# CITY OF ALBUQUERQUE

March 23, 2017

**RE:** Carmel Ridge Subdivision  
Grading and Drainage Plan  
Engineer's Stamp Date 3-15-2017 (File: C20D075)

**RE:** Carmel Ridge Subdivision  
Grading and Drainage Plan  
Engineer's Stamp Date 12-16-2016 (File: C20D075)

CARMEL RIDGE SUBDIVISION  
BEING A REPLAT OF LOT 29, BLOCK 3, UNIT 3, TRACT 2, NAA  
GRADING & DRAINAGE PLAN

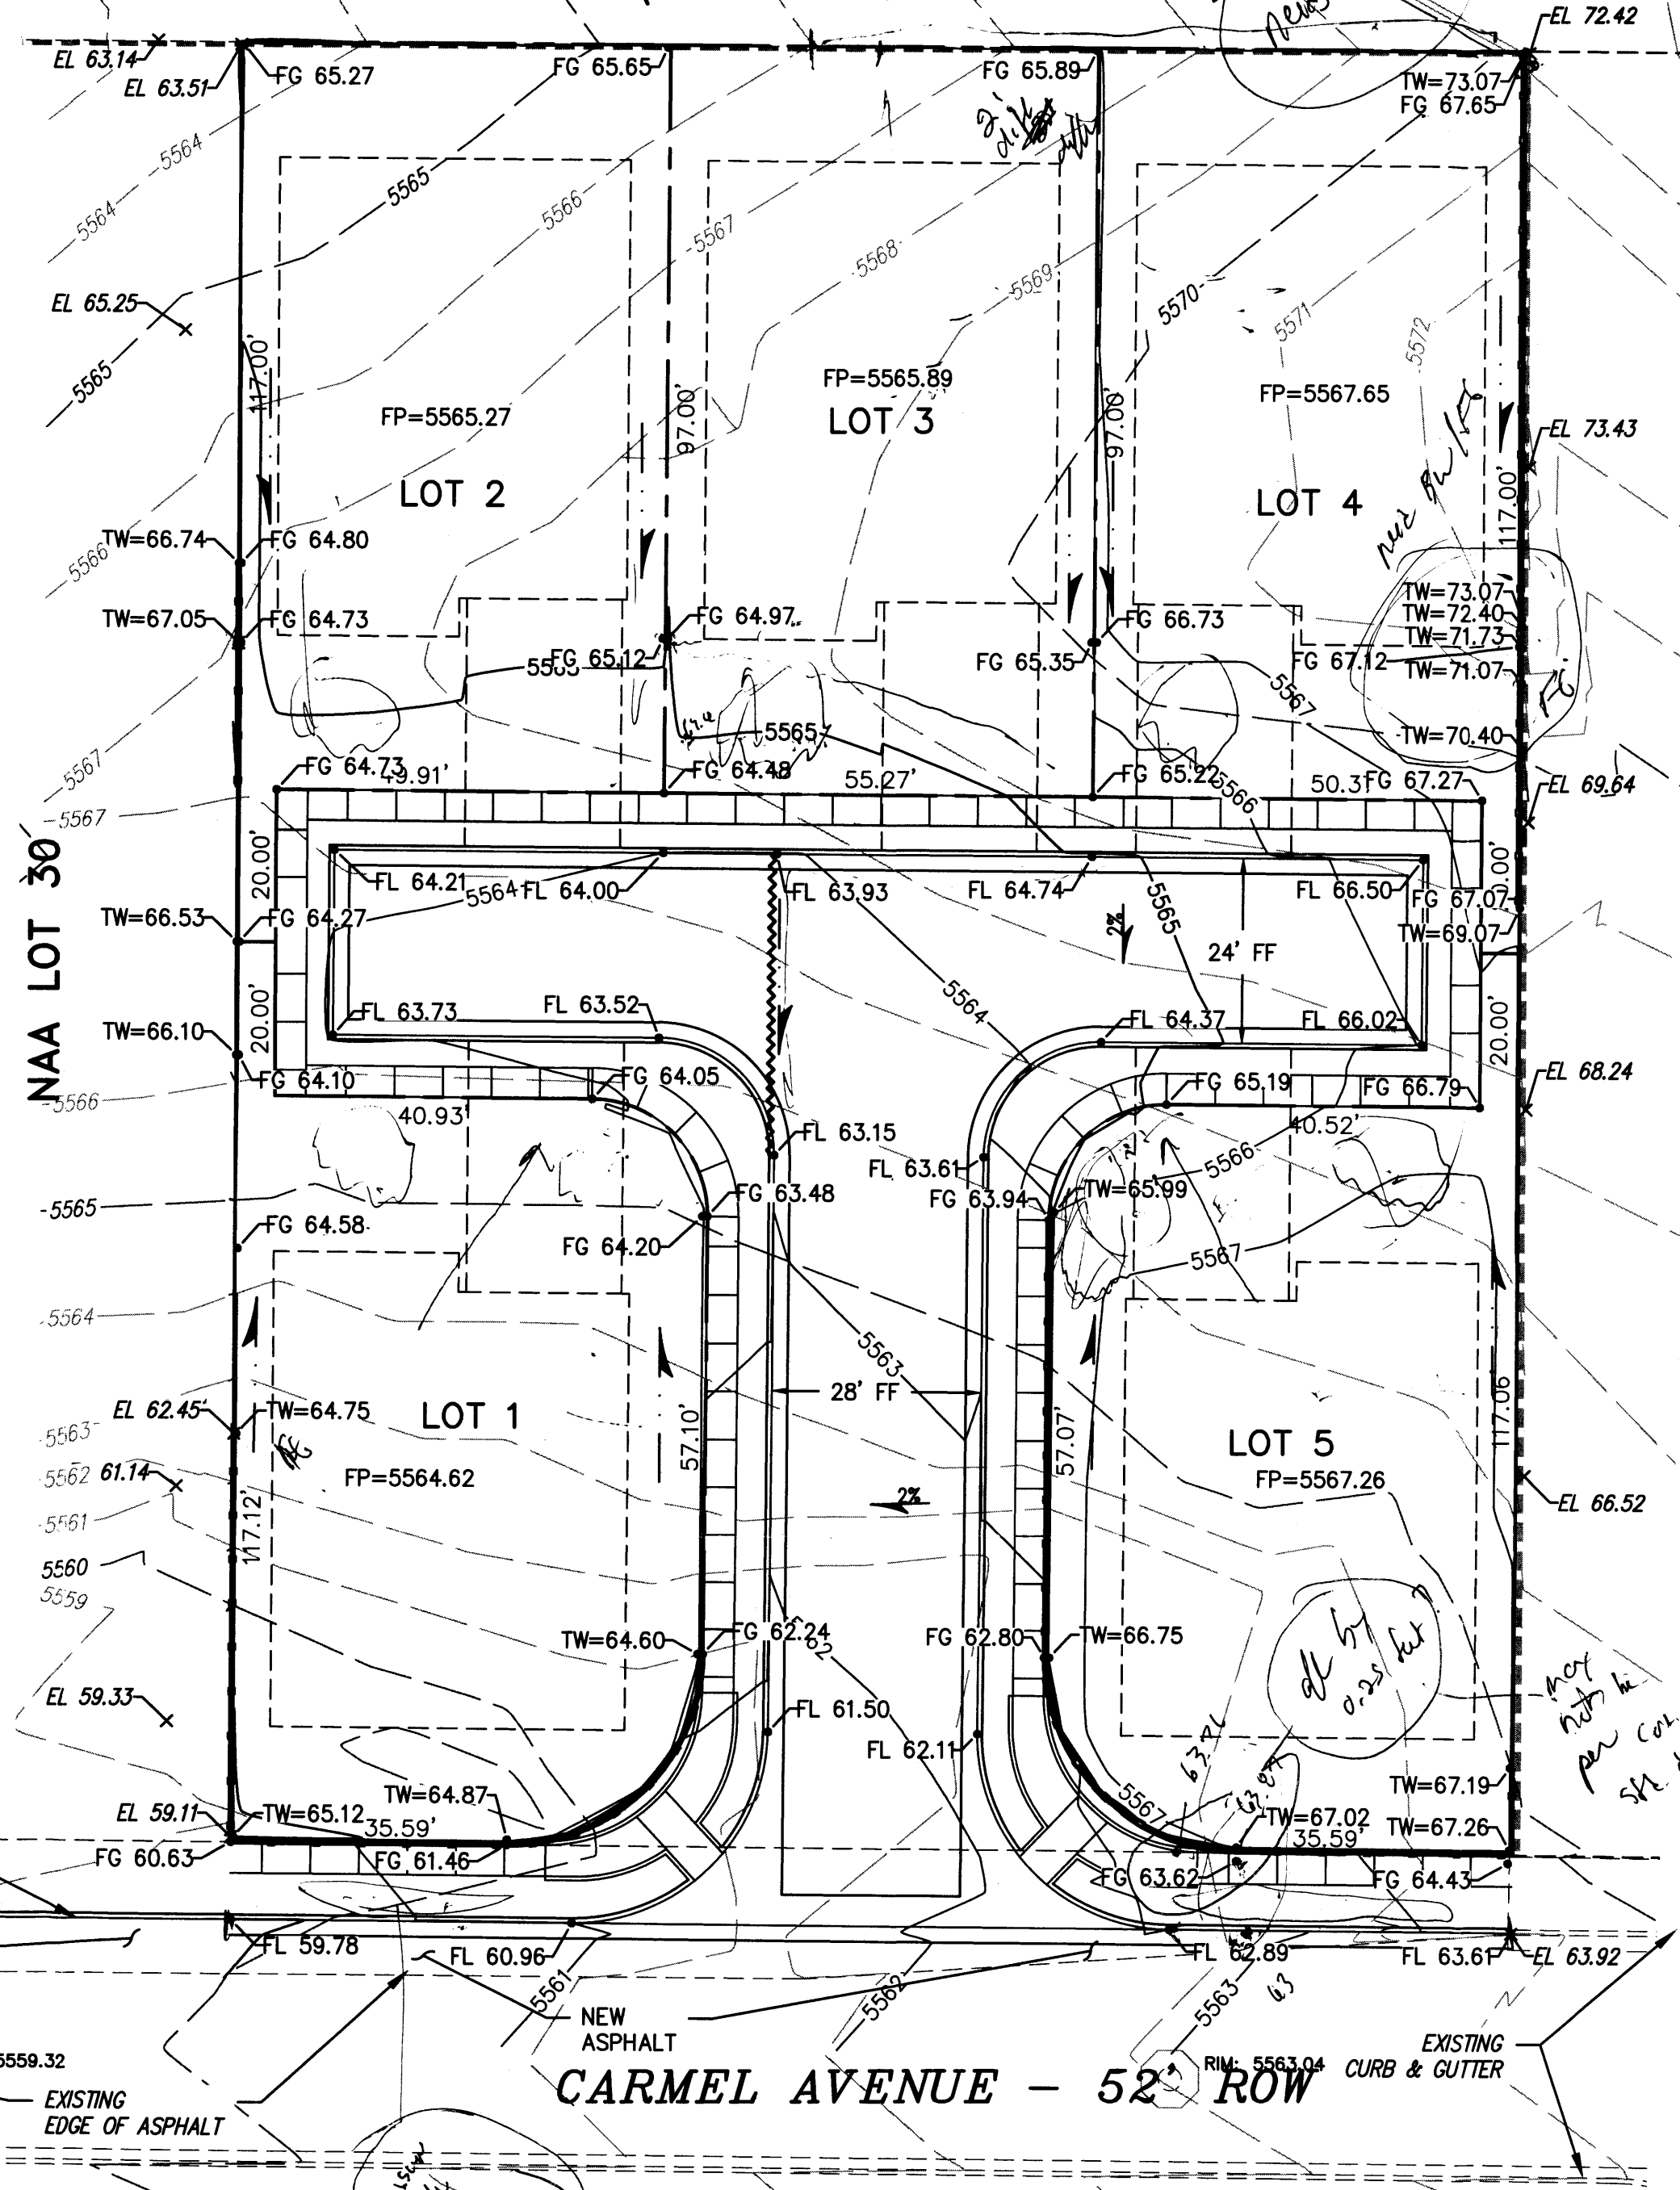
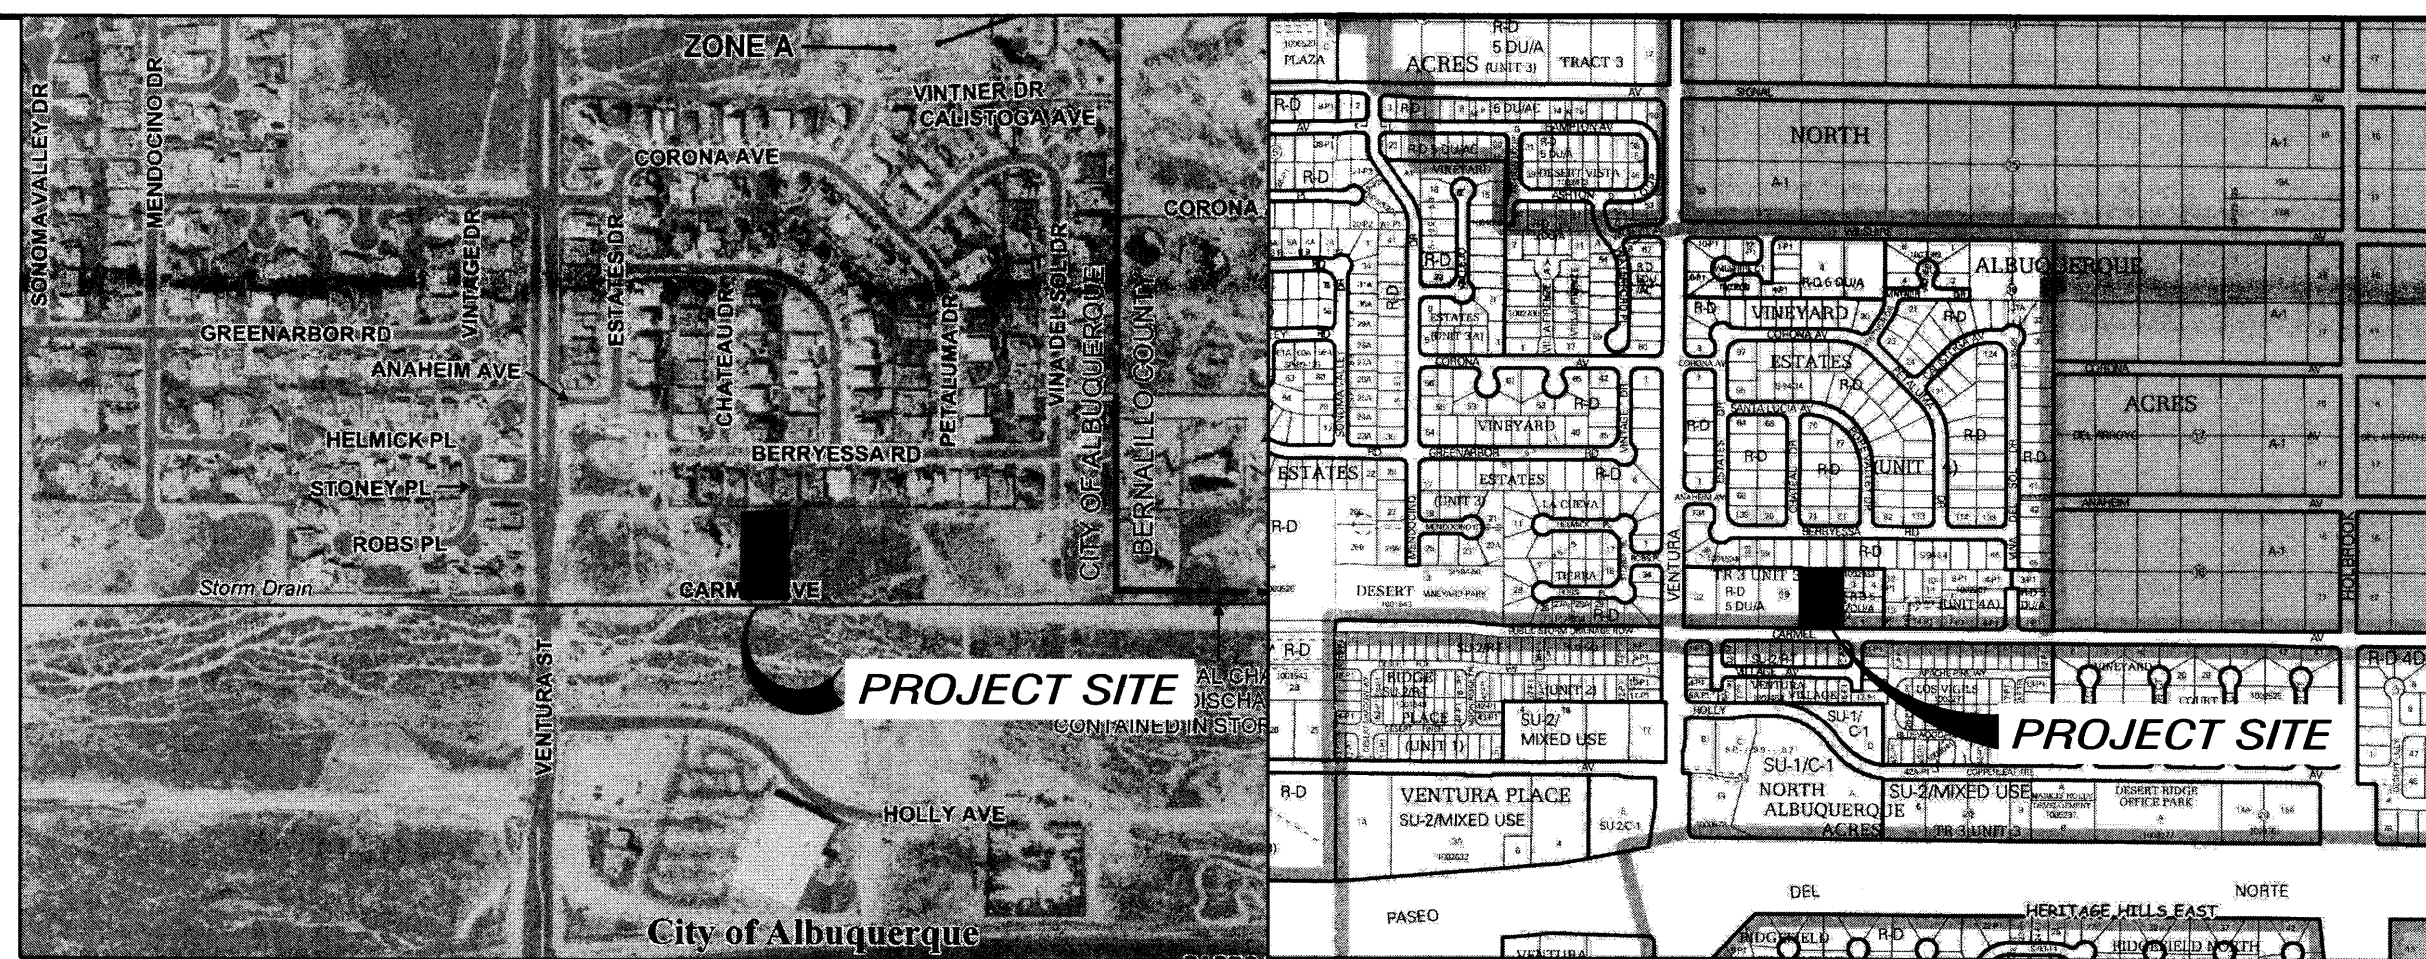
- ✓1. Provide a retaining wall on the north of lot 3 and lot 4, where difference between existing and proposed grades is 2 feet or greater.
- ✓2. Provide FG grades in the south east area of lot 4. There are TW grades, but no BW/FG grades
- ✓3. Please check the grade elevation between the flow line and back of side walk, as it seems to not meet the city standard; curb height plus 2% from top of curb to back of sidewalk.

1. The grade of Lot 3 has been changed to closer match existing elevations, and the retaining wall has been extended.
2. Finished grade elevation is indicated
3. The elevations have been verified from flowline of mountable curb to back of sidewalk.
